CITY OF ALBUQUERQUE

December 6, 2022

Re: Starbucks
4201 Central Ave. NW
30-Day Temporary Certificate of Occupancy
Transportation Development Final Inspection
Architect's Stamp dated 01-06-22 (K12-D005A)
Certification dated 11-28-22

A2 ENLARGED SITE PLAN
SCALE: 1:20

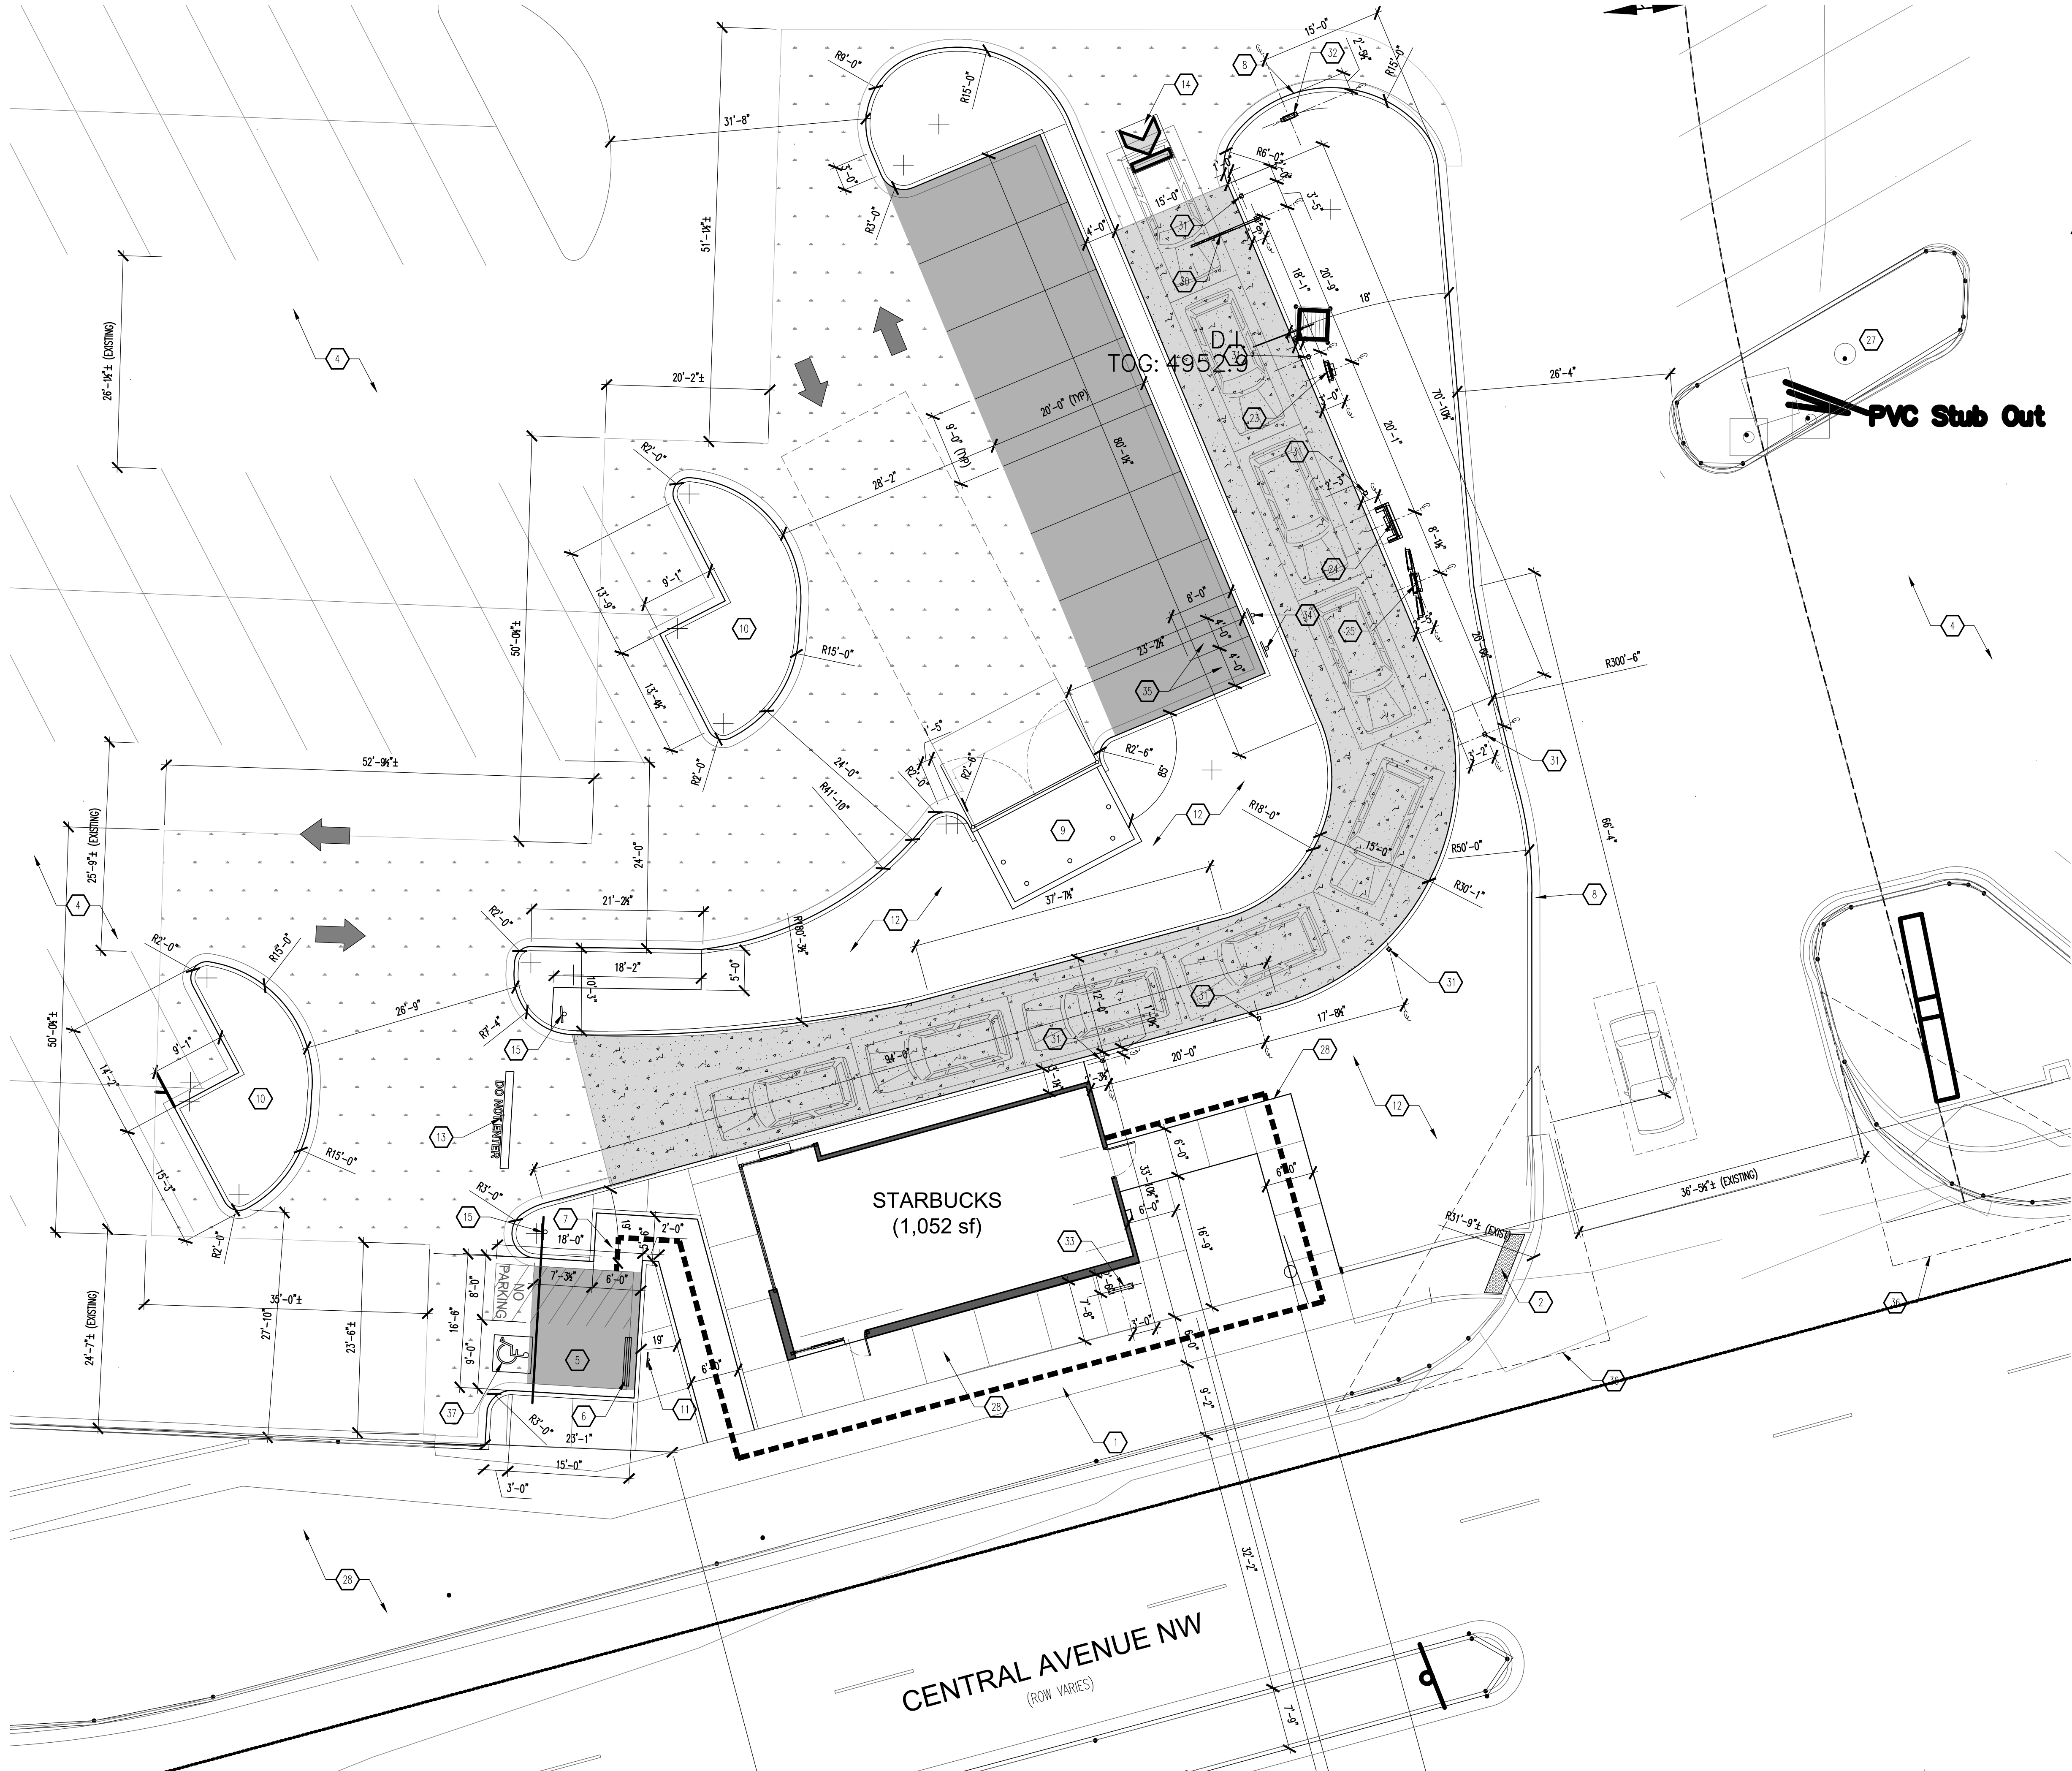
- Please remove construction equipment and debris from site.
- Tripping hazard (key note 2): please fix the installation of the Truncated Domes at the City Right of Way ramp for a smooth transition.
- All disturbed area must be stabilized, prior to final CO.
